30 June 2020  
Our Ref: 20550B.2ER\_Submission

**Submission in relation to  
SSD 10376 Sydney Metro Pitt Street (South) Over Station Development – Stage 2 and  
SSD 8876 MOD 2**

DFP Planning (DFP) has been engaged by the Owners of SP51077, being the Princeton Apartments building which is located at 304 – 308 Pitt Street, Sydney.

**Figure 25 | Building separation distances (in mm) between proposed building and Princeton Apartments (Base source: RTS)**

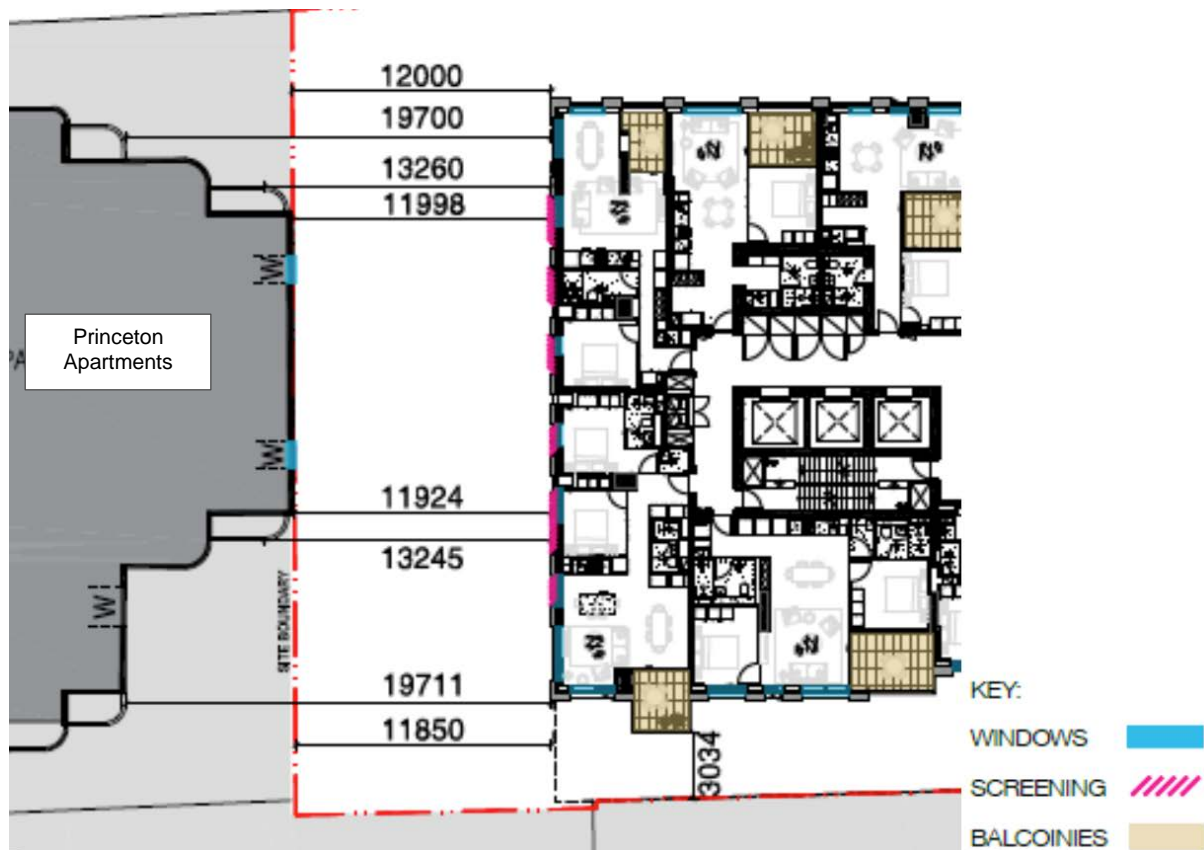
The distances set out in Part 2F of the ADG are a **minimum separation** requirement, not a **setback** requirement. Therefore, where there is an existing approved building on an adjoining site, it is incumbent on the new development to provide the required building separation.

Princeton Apartments is an approved development which is built to the northern boundary of the lot on which Princeton Apartments is located. Therefore, the separation required to be provided between the existing Princeton Apartments tower and the proposed residential tower is 24m.

The plans submitted in relation to the Stage 2 DA propose a setback of less than 12m (11.5m<sup>1</sup>) from the southern property boundary above RL 58.75. Below RL 58.75, a 0m setback is proposed.

In this regard, the statement in the Architectural Design Statement (Appendix E to the EIS) that “*The SSDA envelope proposes a 12m setback to Princeton Apartments to the south, measured to the glazing line, which is complying with minimums required under the ADG and consistent with the approved building envelope*” is incorrect as a minimum setback of **24m** is required to be provided to the southern site boundary in order to achieve a compliant building separation between the proposed OSD and Princeton Apartments.

In its current form, the proposed development is inconsistent with the ADG and therefore, is non-compliant with Condition B3(h). Therefore SSD-10376 cannot be approved in its current form.

**Figure 29 | Possible stepped building arrangement to achieve a varied Pitt Street setback (Base source: Amended RtS Plans)**

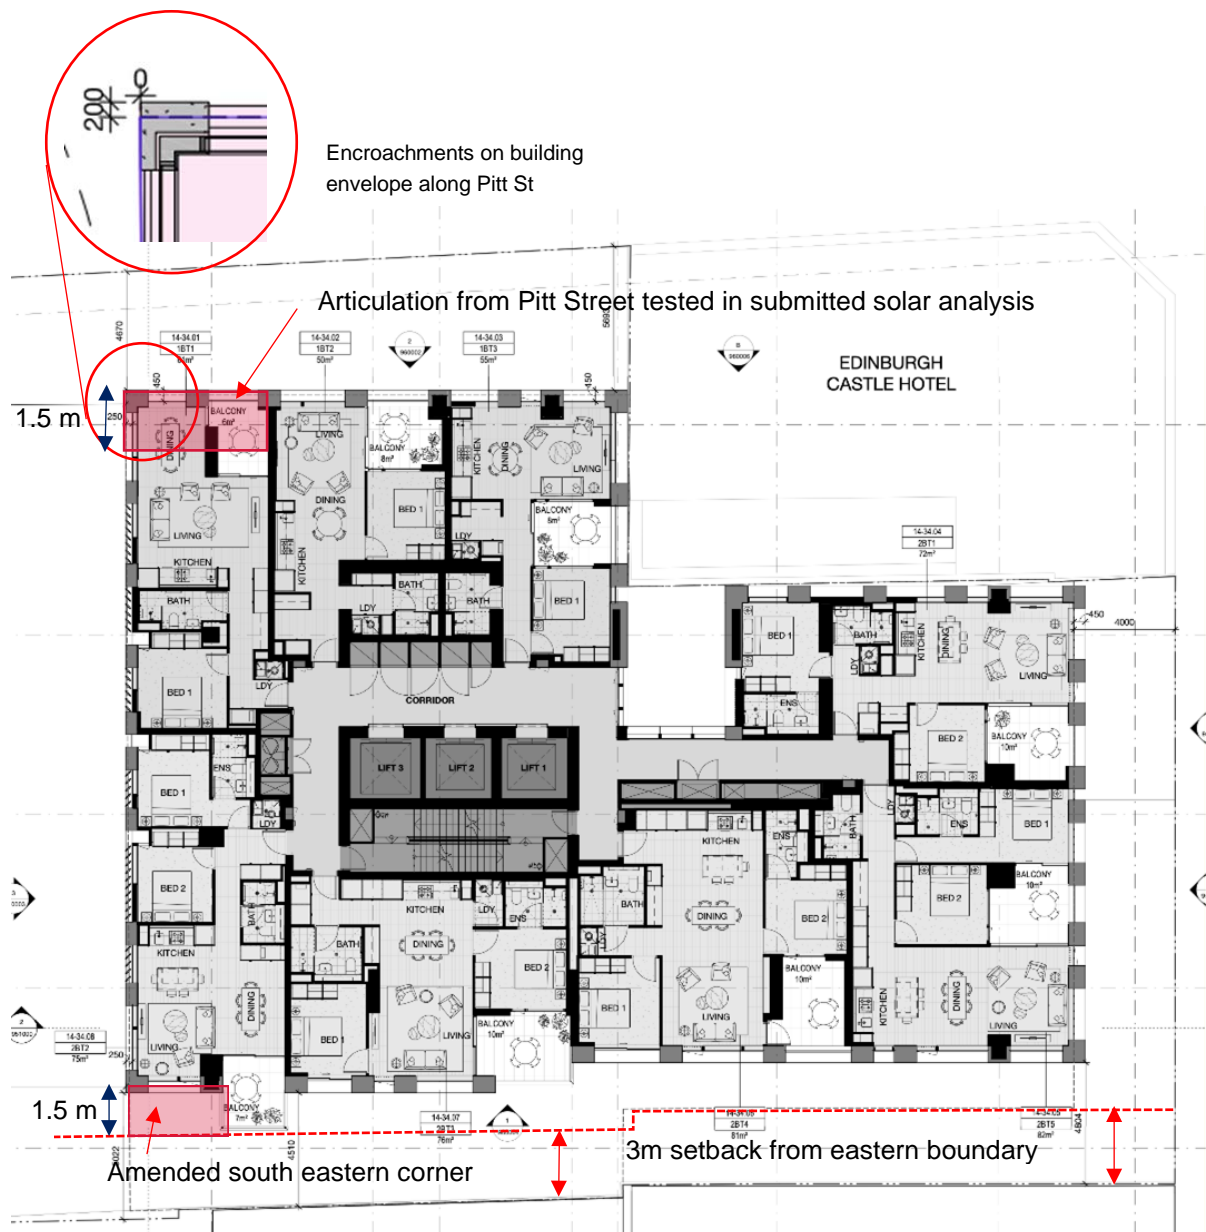
Condition B3(e) requires the Pitt Street setback to be varied to *minimise solar impacts to the living rooms of Princeton Apartments*. As discussed below, the proposed development has not been designed to minimise solar access impacts to the living rooms of Princeton Apartments and therefore is contrary to Condition B3(e) of SSD-8876.

As it is currently designed the proposed development is inconsistent with Condition B3(e) of the consent issued in relation to SSD-8876 as it has not been designed to *minimise solar impacts to the living rooms of Princeton Apartments*. It must also be emphasised that changing the development from a residential development to a commercial development would still fail to achieve compliance with Condition B3(e), due to the significant impacts on the solar access to Princeton Apartments.

**Figure 30** | The submitted solar analysis identified that windows on Princeton Apartment receiving full sun at 10 am mid winter (Source: Applicant's solar analysis – 17/12/2020)

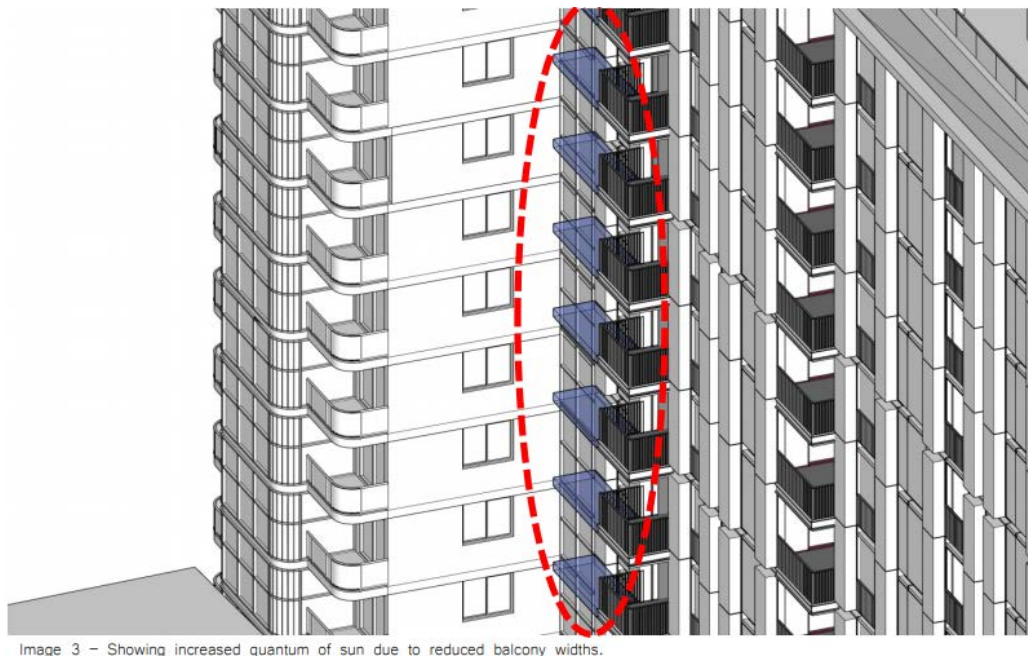
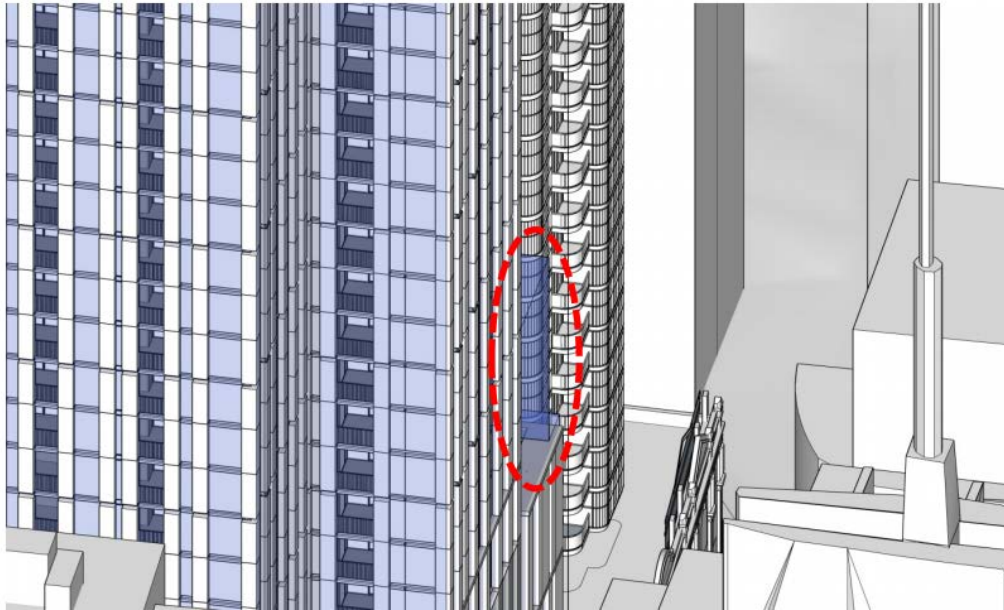
Table 2 in this report details that 54 of the 116 (46.5%) apartments within Princeton Apartments currently receive 2 hours of solar access in mid-winter.

Table 2 also notes that only 6 of the 116 Princeton Apartments (or 5%) will receive 2 hours of solar access in mid-winter between 9am and 3pm once the OSD development is constructed.

Therefore, in relation to solar access, the proposed OSD is contrary to Condition B3(h) as the percentage of Princeton Apartments that will receive the required amount of solar access does not comply with the design guidance criteria as set out in Objective 3B – 2 of the ADG.

The Walsh<sup>2</sup> Analysis report acknowledges that *the overshadowing impact of the proposal reduces this proportion [being the proportion of Princeton Apartments dwellings receiving the required 2 hours of solar access in mid-winter] to 6/116 (5.2%), which clearly cannot be said to simply conform with the ADG Design guidance.*

Based on the fact that the number of apartments within Princeton Apartments that currently receive a minimum of 2 hours of solar access in mid-winter does not meet the 70% benchmark as required by the ADG, **any** development on the adjoining property that reduces the number of apartments in the Princeton that receive at least 2 hours of solar access is not compliant with the ADG and should not (and cannot) proceed.
